BOLLO BROOK HOUSE

Full Element Plot 3A

Comparison Drawing Pack: S96A
Addendum

Allies and Morrison

S96A Proposal: Level 1 Floor Plan - BOLAN-AAM-BA-22-DP-AR-07101

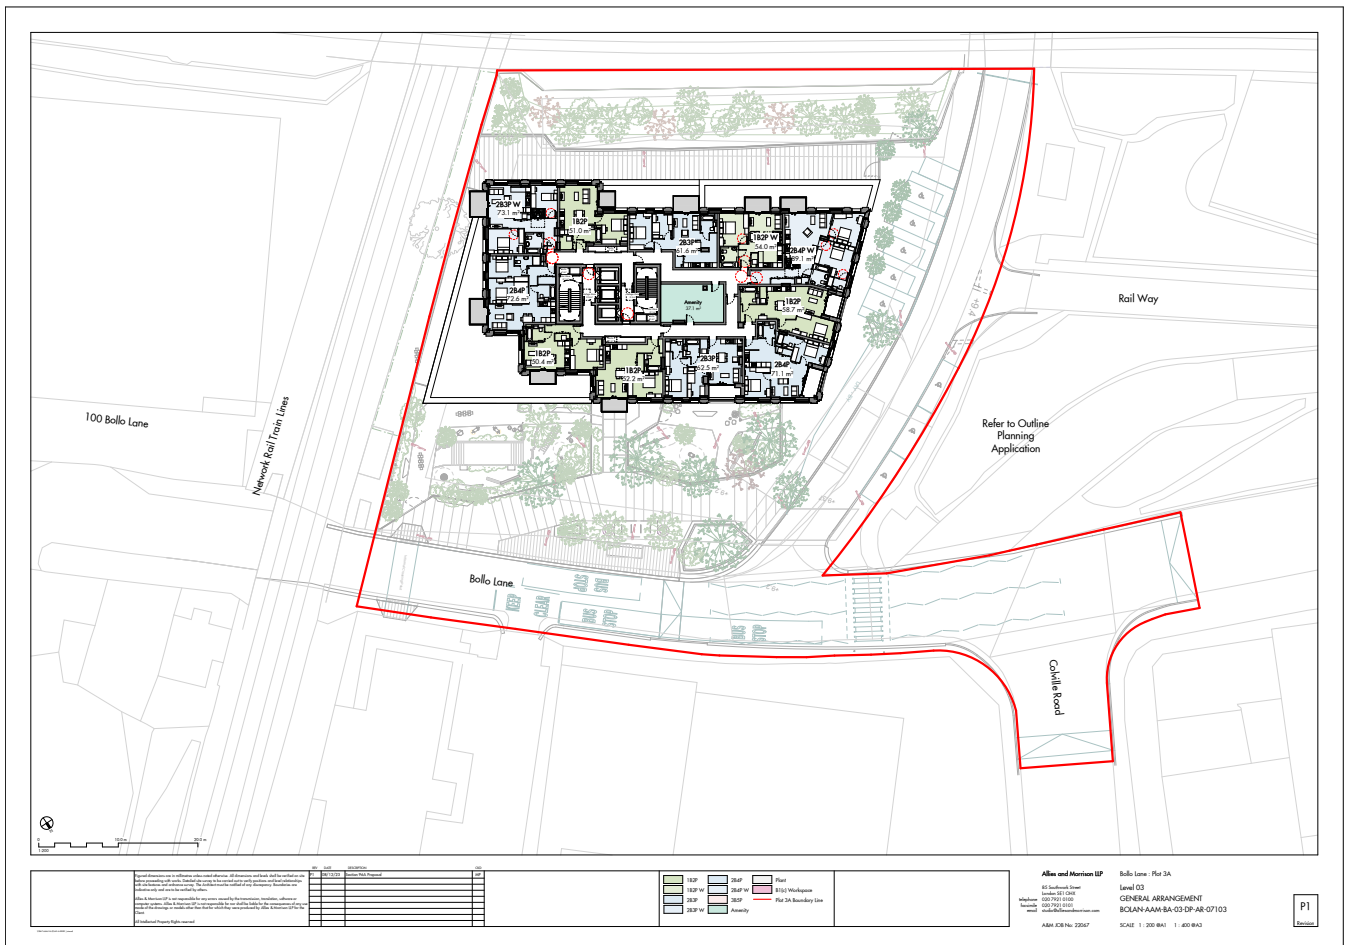
For clarity of information and accuracy of information this S96A proposal consolidates the residential mezzanine floor plan and Level 1 Light Industrial Level Floor Plan of the 2021 Permission into a single Mezzanine Level Floor Plan.

S96A Proposal: Level 3 Floor Plan - BOLAN-AAM-BA-22-DP-AR-07103

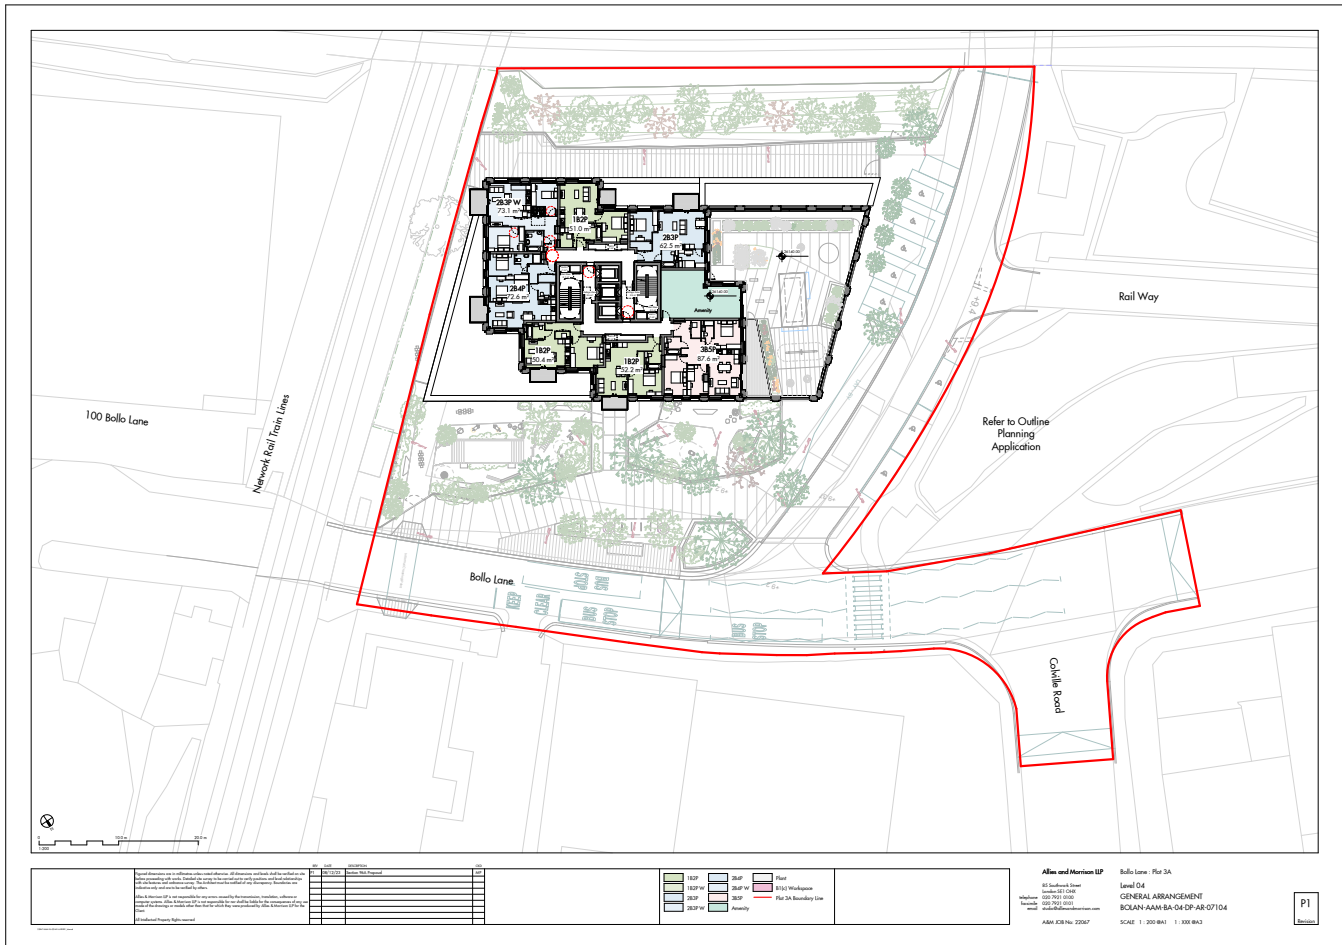
The S96A proposal separates the Level 2-3 floor plan to two individual drawings to distinguish between the terrace and balcony private amenity spaces.
